Subject: RE: Planning Consultation on: LU/144/22/DOC - Condition 7 - Construction Management Plan. Land South of the Academy

Application No: LU/144/22/DOC

Site Address: Land South Of The Littlehampton Academy Fitzalan Road Littlehampton BN17 6ED

Description of Works: Approval of details reserved by condition imposed under ref LU/116/21/PL relating to Condition No 7 - Construction Management Plan.

Client	Bo'lyok		
Project	Land to the south of Ullingham Academy		
Drawing No	Vehicle Sweep Path Assessment	BROHUIS 3-AXLE DELIVERY	
Drawing No.	4806	Rev.	R03
Issue	As Shown	Drawn by	DLH
		Checked by	SAJ
		Approved by	A

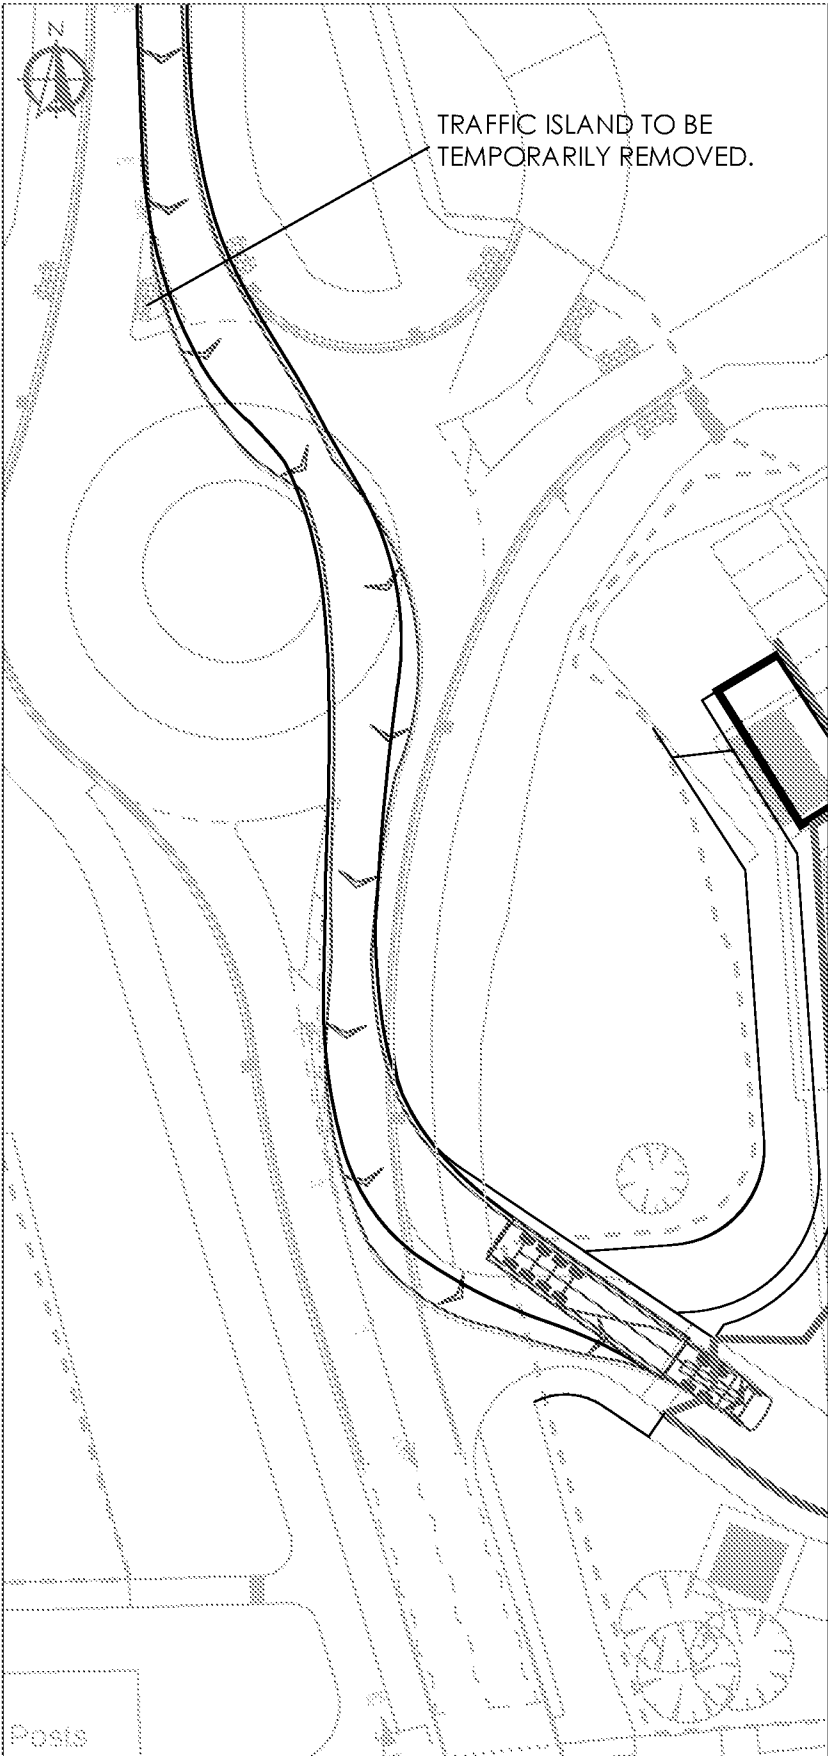
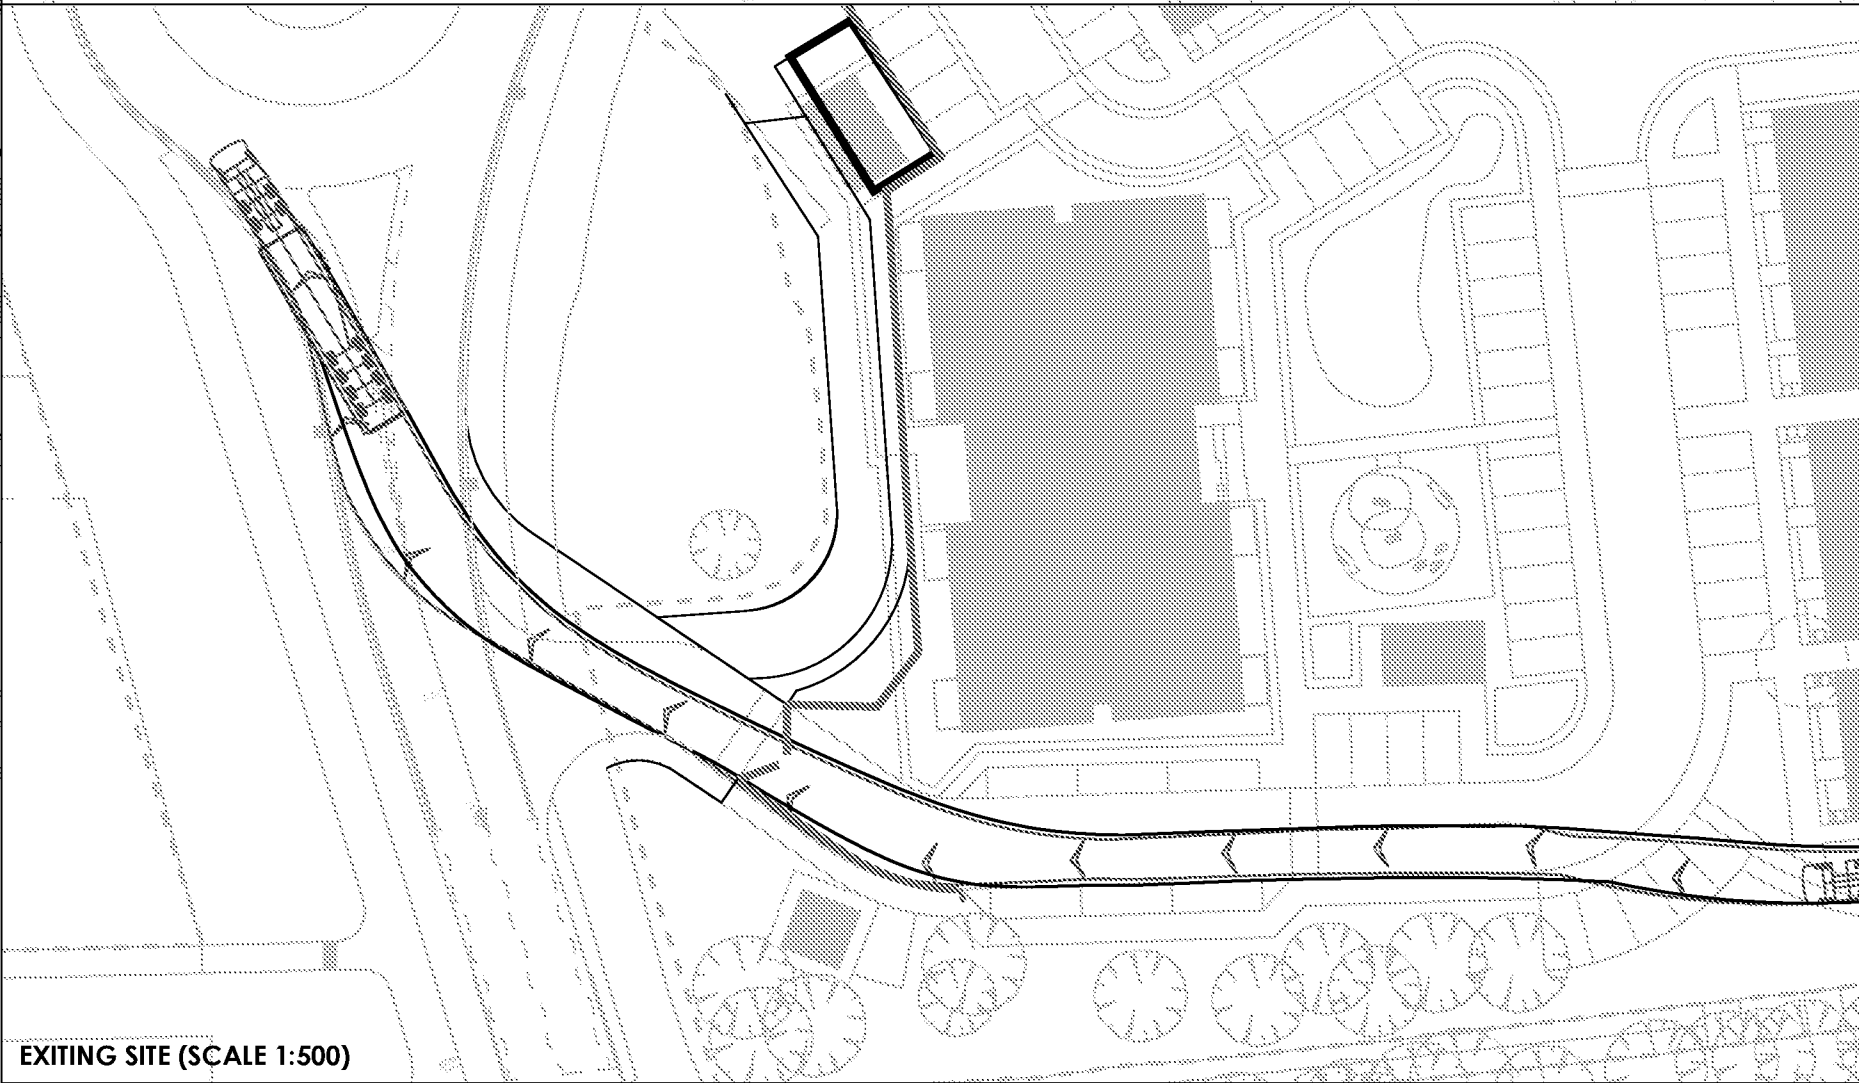
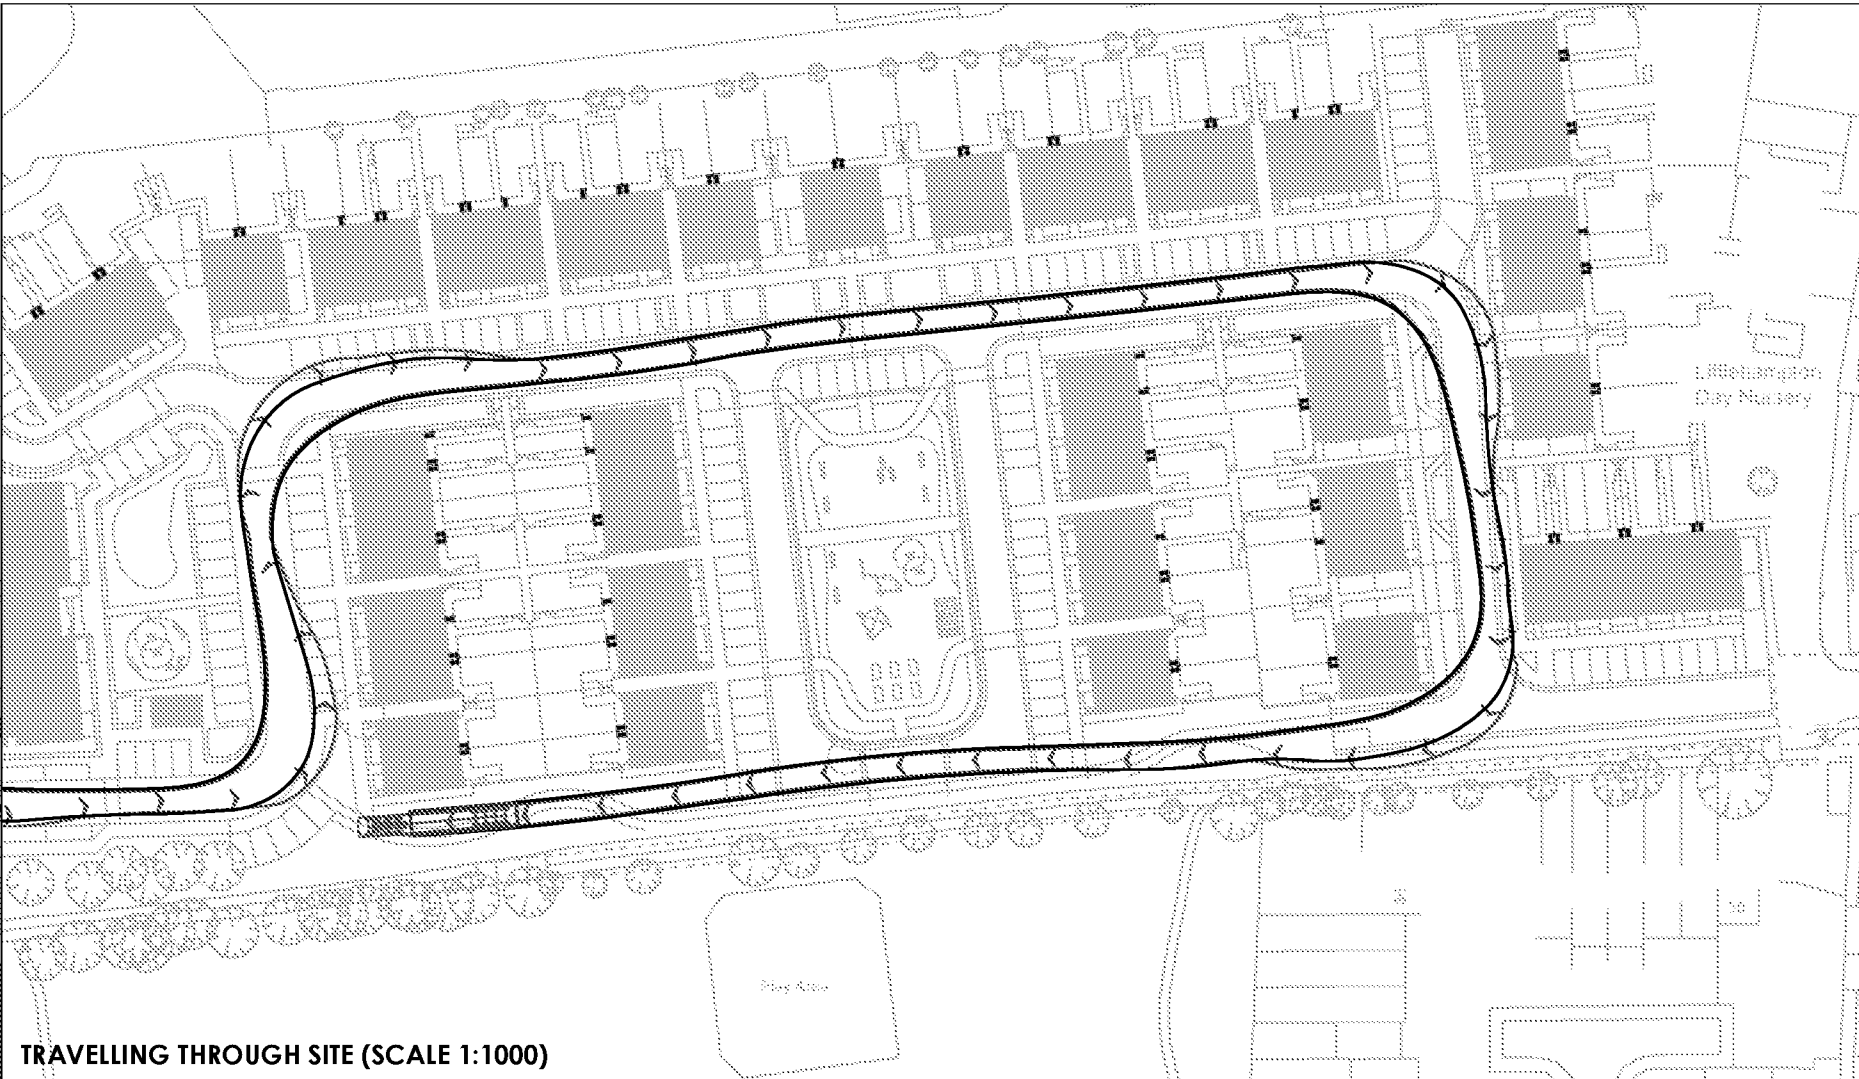
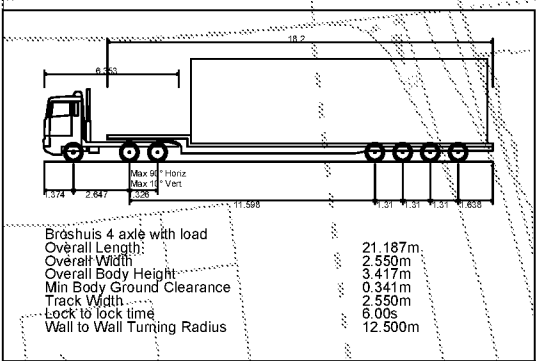
In submitting the revised CMP and updated vehicle tracking, it's apparent that the more onerous delivery vehicle requires more involved temporary mitigation works, namely the removal of the splitter island on the northern arm of the academy roundabout on Fitzalan Road. This isn't particular desirable as the splitter island is well used by pupils attending the Littlehampton Academy. Alternate options should be explored to determine if the splitter island does need to be removed or whether there are alternate options. Such options along with any associated mitigation, can be determined directly with WSCC given that no changes can be made to the highway network without the permission of WSCC.

The tracking drawings also raise the concern as to whether further temporary offsite works will be needed at other roundabouts. Whilst this will be for the applicant to determine, again in discussion with WSCC, for the purposes of the current CMP it would be requested that the newly constructed roundabout on the A259/Fitzalan Road is also tracked to determine if any temporary works are required.
